Application reference number	2026/0428
-------------------------------------	-----------

Proposal Description:	Erection of a single storey portacabin modular building providing nursery facilities
Location:	Brierley Church Of England Primary School, Beech Close, Brierley, Barnsley, S72 9EJ

**3** Rear Elevation  
1 : 100

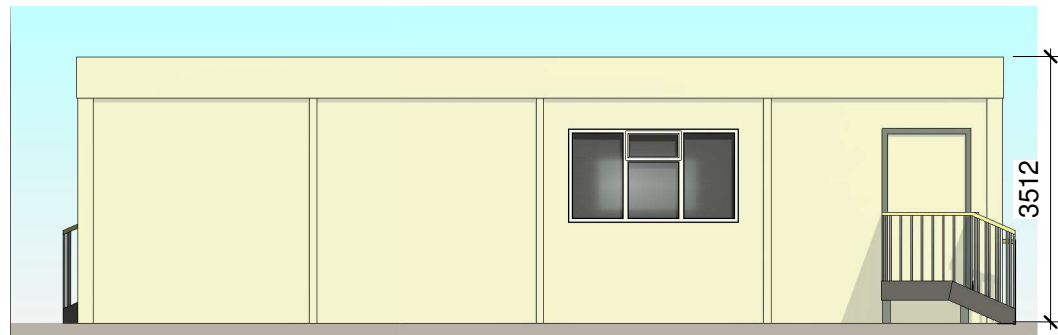
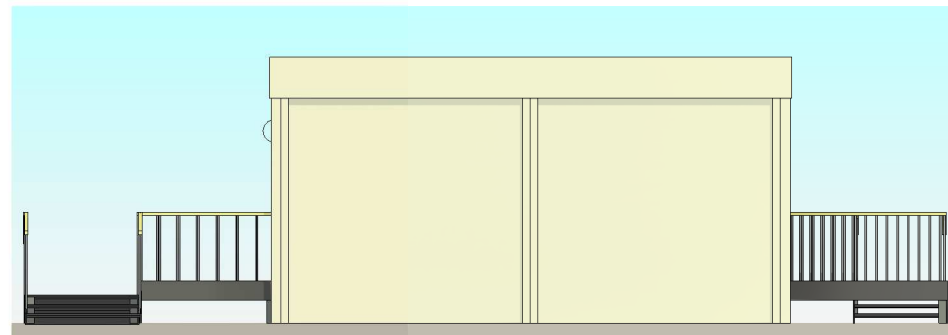
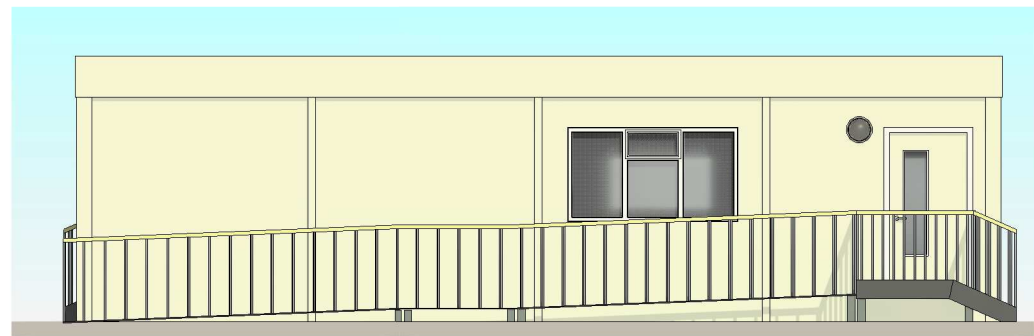
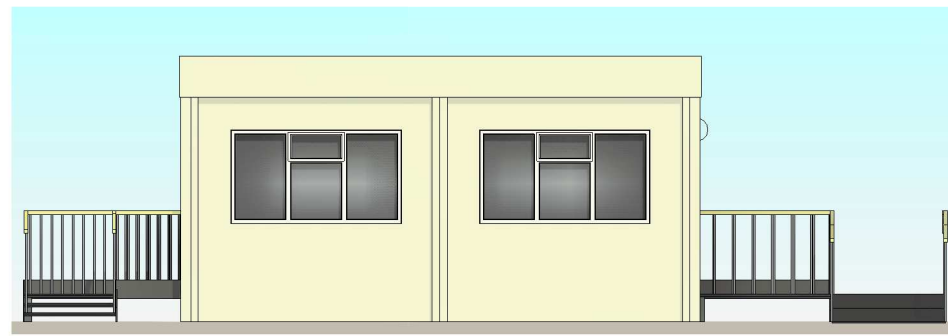
Notwithstanding this, concerns were initially raised regarding the design quality and visual appearance of the proposed portacabin. In response to these concerns, amendments have been made to incorporate a timber-effect vinyl wrap to the external elevations. Whilst this does not fully overcome concerns regarding the temporary and utilitarian appearance of the structure, it represents an improvement over the originally submitted design and helps to soften its visual impact.

The Design and Conservation Assistant indicated a preference for higher quality external materials. However, discussions with the agent confirmed that the available project funding does not allow for additional design enhancements. Taking this into account, together with the improved appearance of the amended scheme, it is considered that, on balance, the proposal is acceptable in this instance. Furthermore, the portacabin will be well screened

from public view, particularly the rear elevation, which is not proposed to be treated with the timber-effect wrap, thereby limiting its visibility within the wider conservation area.
